RMG Response Letter to—Development Plan and Final Plat for Northcrest Flex Space PPR

PCD File No.: PPR-21-036

Fourth Review Letter

Subject: Northcrest Flex Space
2510 and 2522 Canada Drive
Colorado Springs, CO 80922

ENG:	DOV	
DRAWN:	TPT	
CHECKED:	DOV	
DATE:	08/12/2022	
#	REVISION	DATE
JOB NO.:	180649	
SHEET NO.:	C-06

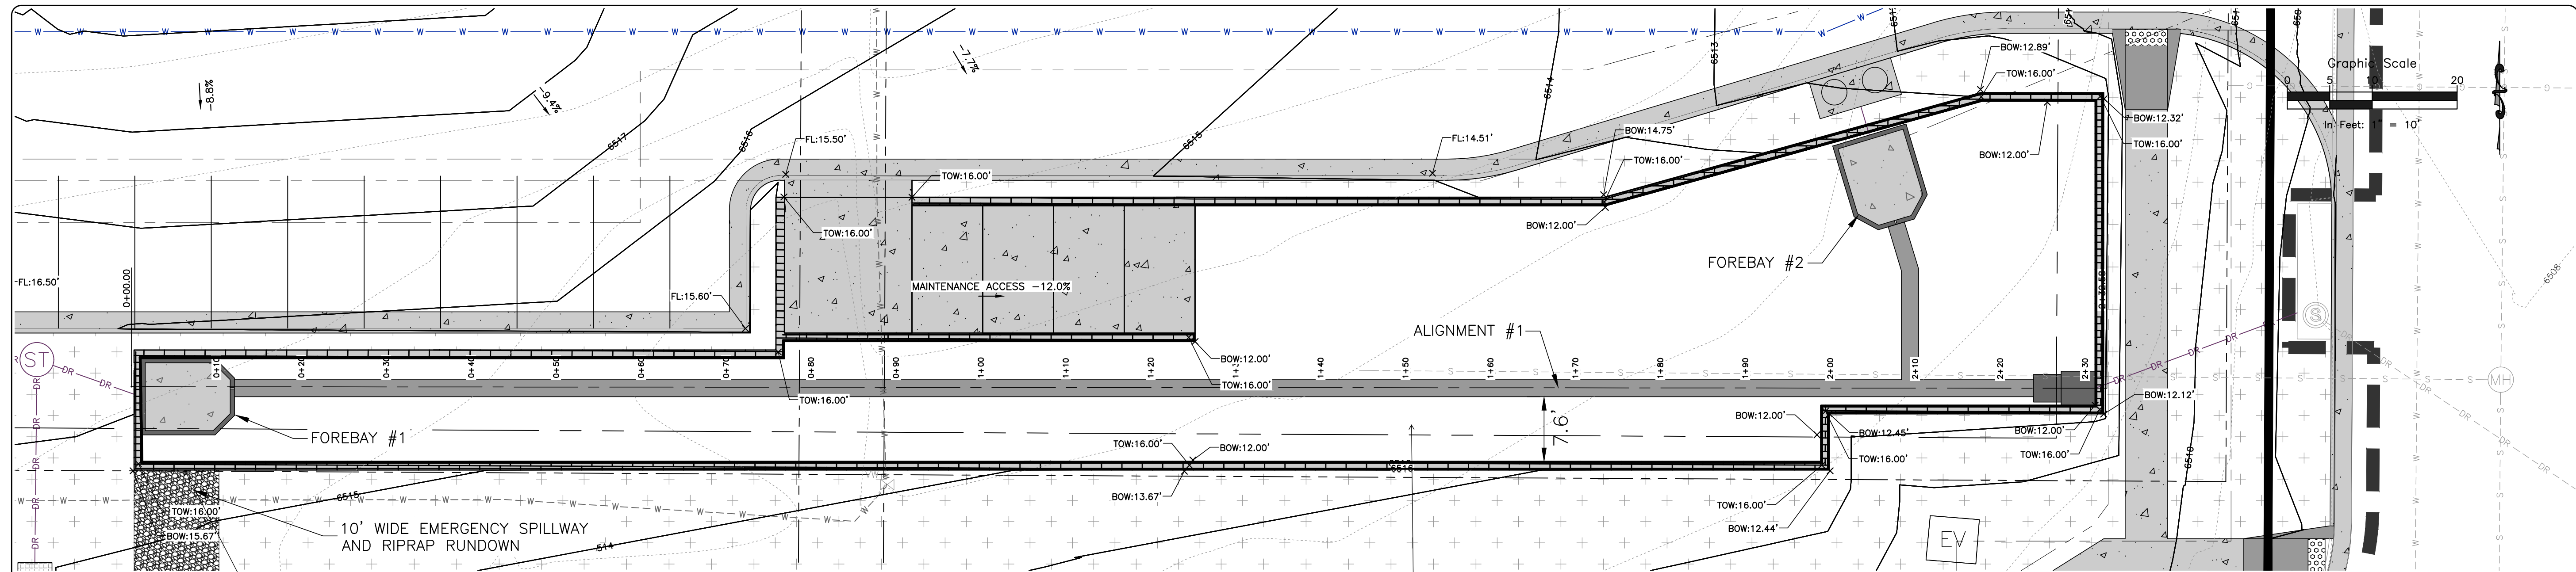
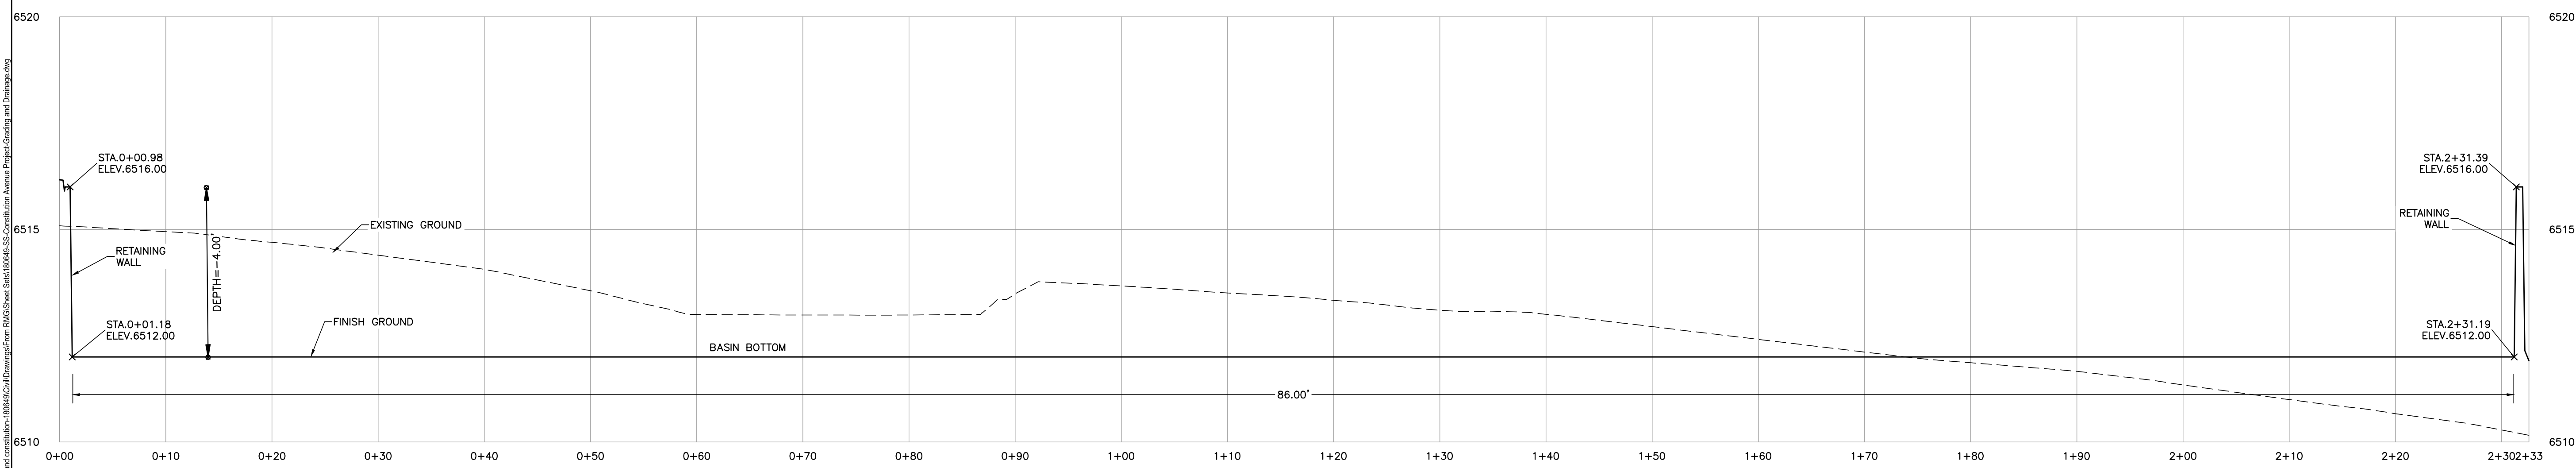
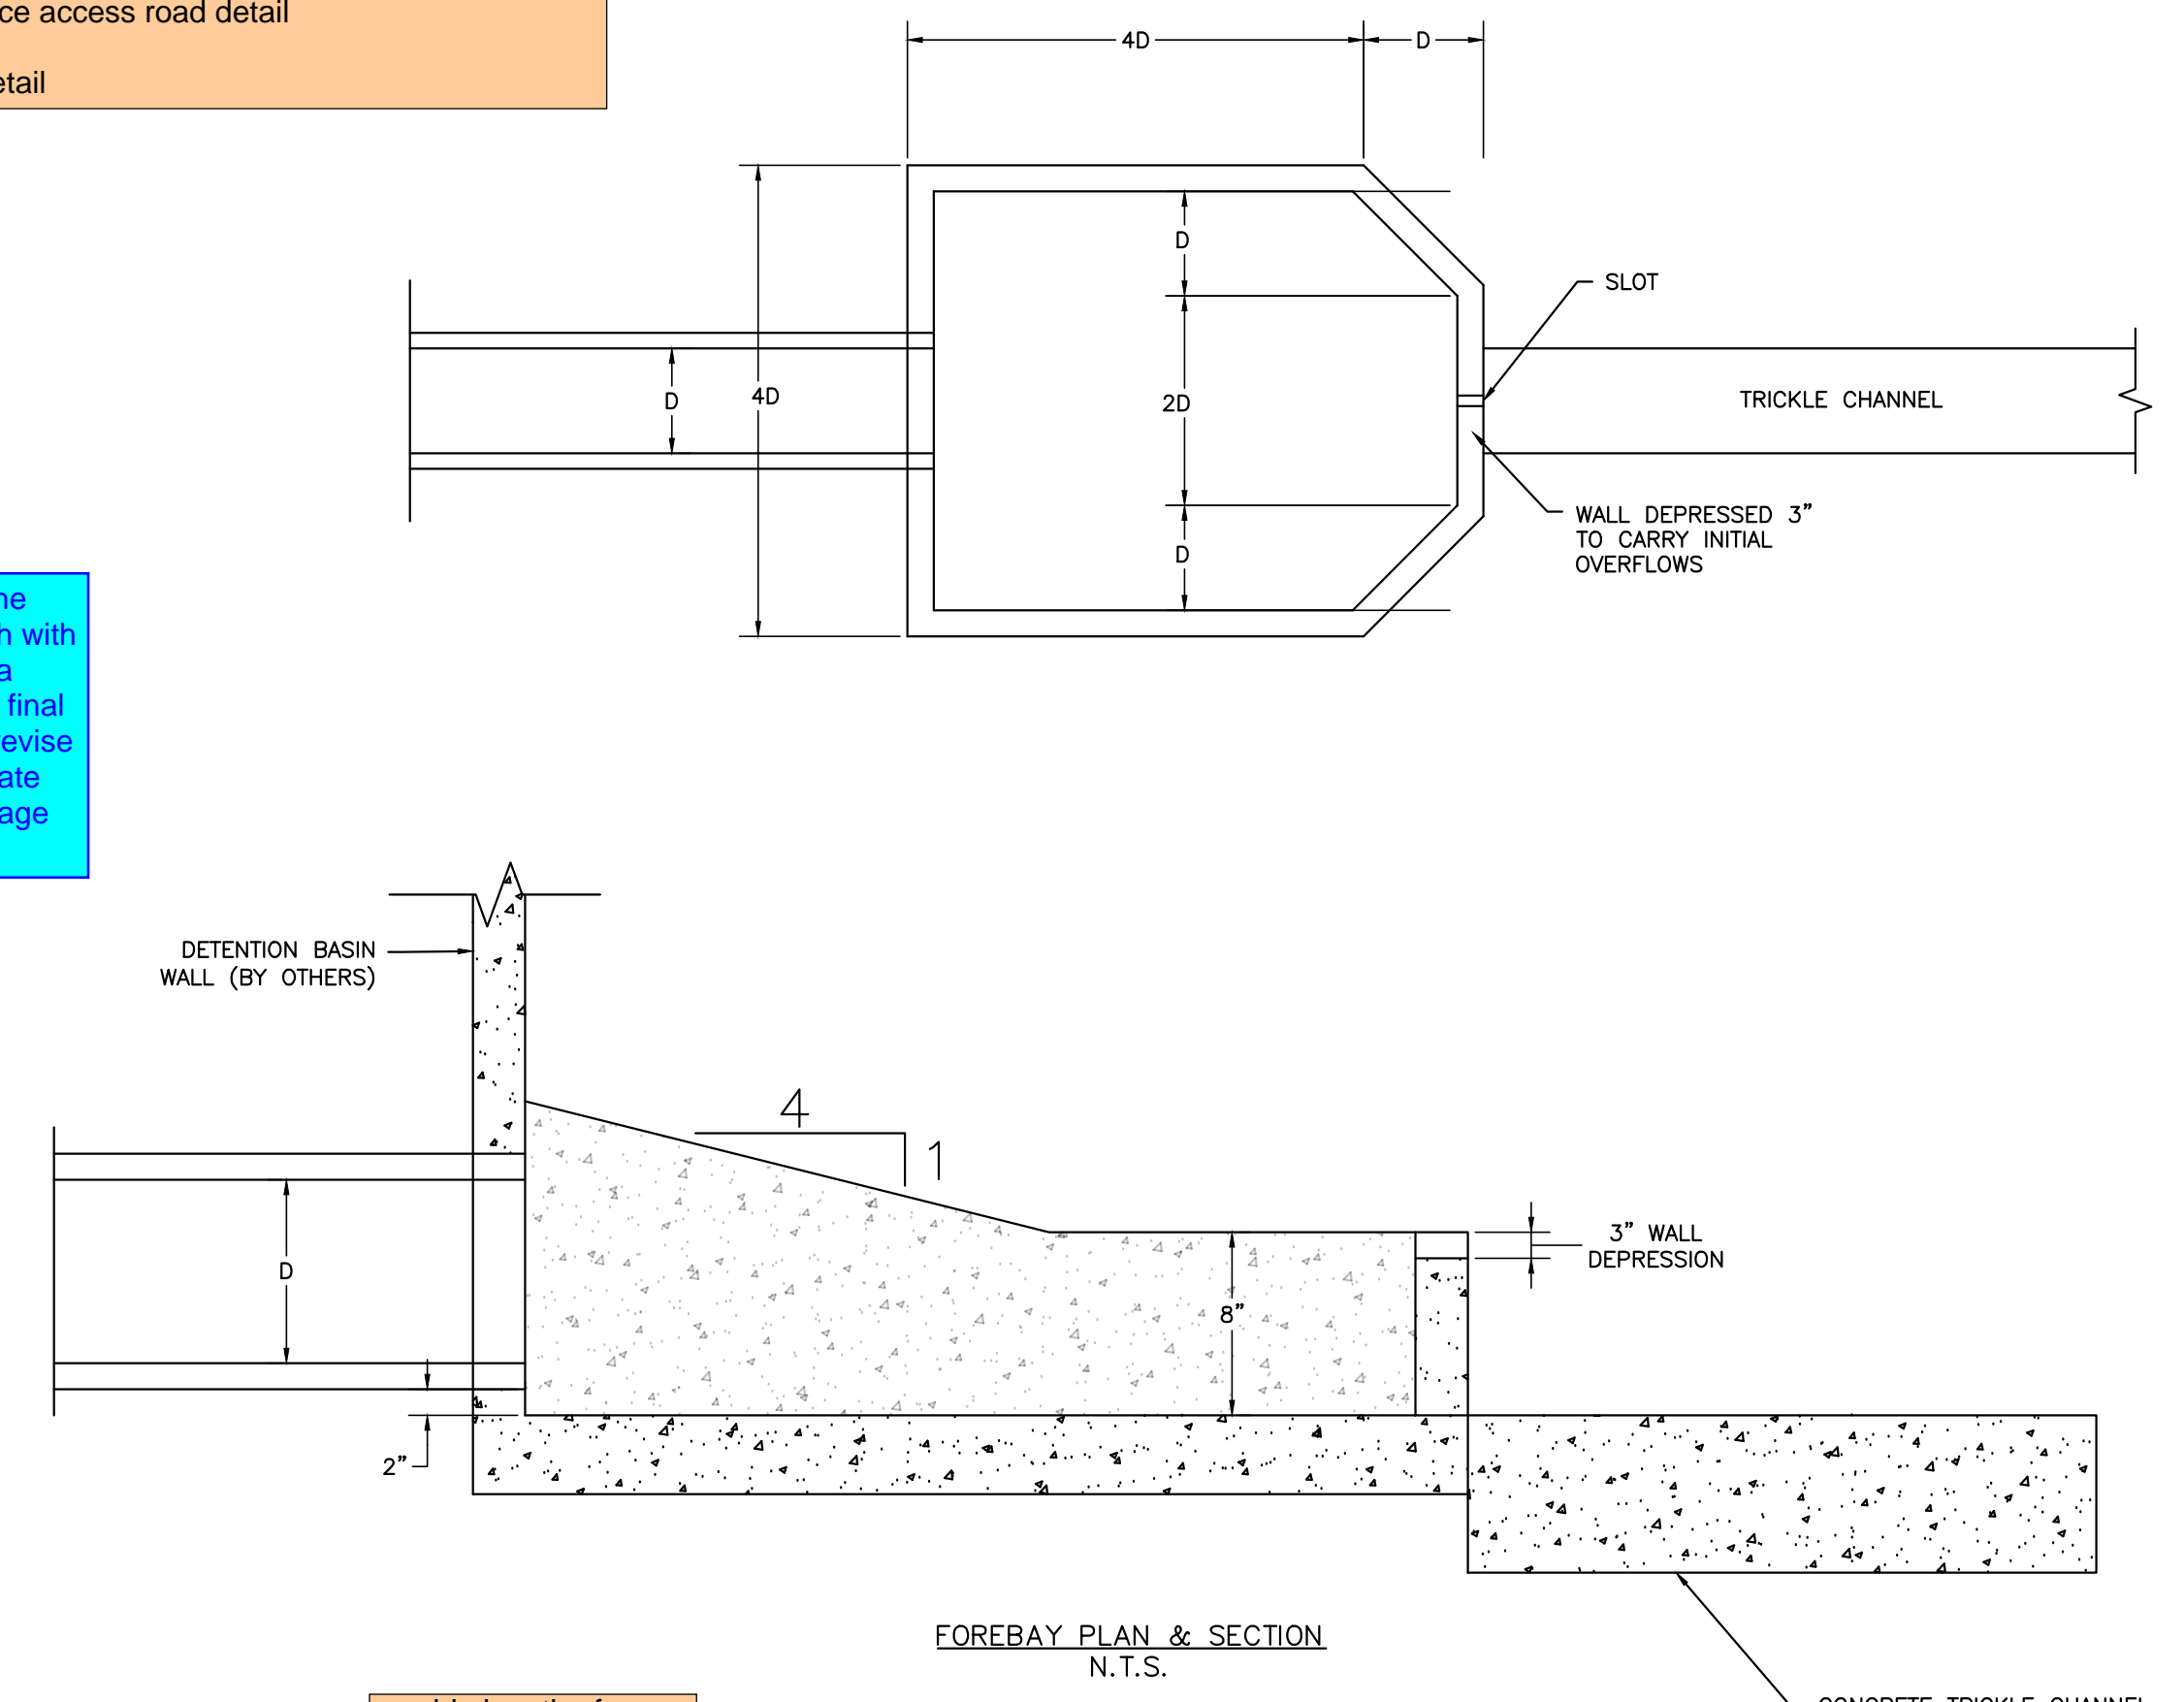
21. ECM SD_2-42 is not shown on this plan. Please include ECM SD_2-42 from the most recent update of El Paso County Engineering Criteria Manual in this plan.
RMG: This detail has been added to the plans.

22. Please revise to 2% max, 1.5% preferred. Adjust all cross slopes accordingly.
RMG: This has been revised.
23. Per criteria this landing must be 2% max at any direction, 1.5% preferred. Typical for all. Please make sure pedestrian ramps meet ECM Chapter 6 ADA requirements. A typical standard detail SD_2-40 can be used. For reference please see attached file.
RMG: This has been revised and the details have been added.

24. Please put a note to reference ECM SD_2-40 and SD_2-41 Pedestrian Curb Ramp Details and provide sheet reference number of standard details.
RMG: The details and callouts have been added.

25. Replace with EPC approved VTC detail (VT-1 and VT-2 in DCMv2, Chap 3.3) or revise to be 75ft min length
RMG: This has been revised.
26. Detail C is not called out in prior sheets. Please provide ECM Standard Detail references in sheet 5 of 12.
RMG: This has been revised.

27. This ramp should match standard detail.
RMG: This has been revised.

28. Highlighted section recommended to be landscaped to prevent people from continuing straight.

29. Please reduce the thickness of the property line so that details are visible.

30. Please revise, proposed design does not match the ECM standard detail drawings. The proposed ped ramp appears to be in the middle of the cross pan. Please make sure slope arrows are pointed in the correct direction with a 2% max cross slope, 1.5% preferred per ECM SD_2-40.

RMG: This has been revised.

RMG: This has been revised.

JOB NO: 180649  
SHEET NO: DP.05  
of 11

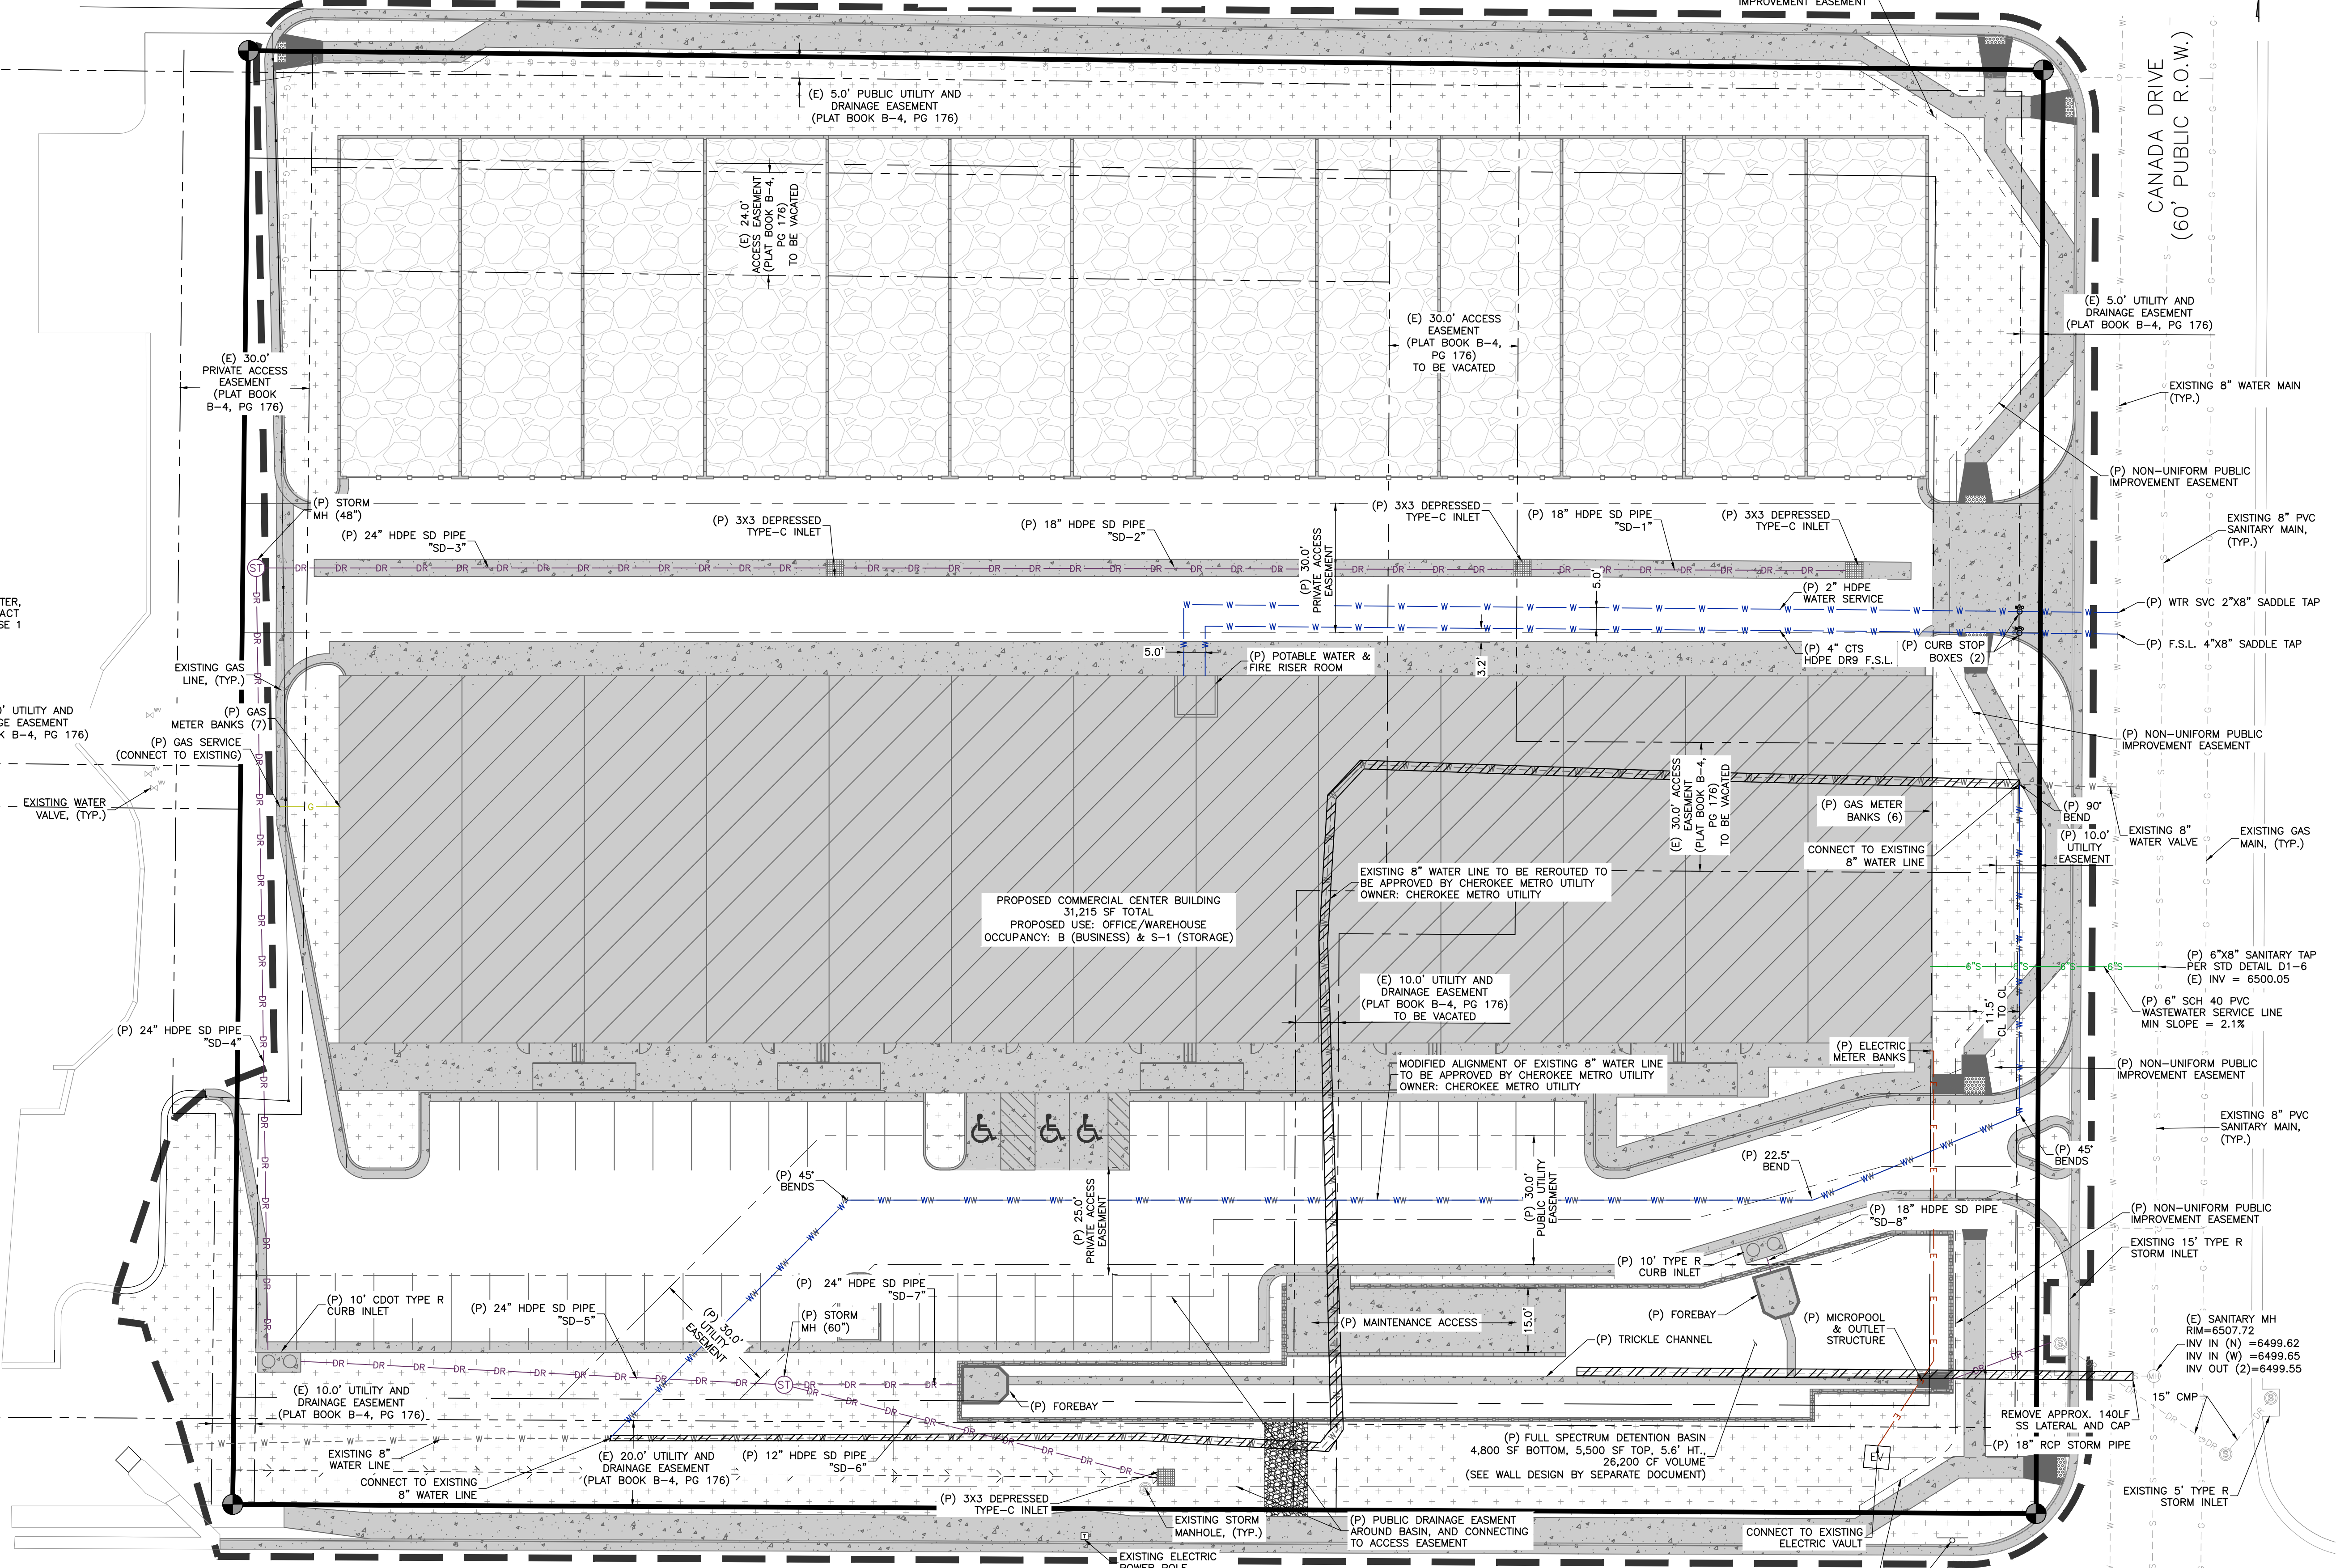
2. Provide 10' out to out separation from existing water main.

3. Provide 30' utility easement at water line.

4. Conflict between existing valve & DR

5. Use 2 45 bend's.
RMG: - The orientation of the water line has been revised. We are now showing a 45 degree bend.
6. Move water line & easement 5' south of concrete curb.
RMG: This separation has been provided for the proposed water line.
7. Install curb box 5' inside Property line.
RMG: Curb boxes have been provided.

RMG: Separation has been provided from existing water main.

RMG: An easement has been provided on the proposed water line.

RMG: This has been resolved with more of the water line being removed.
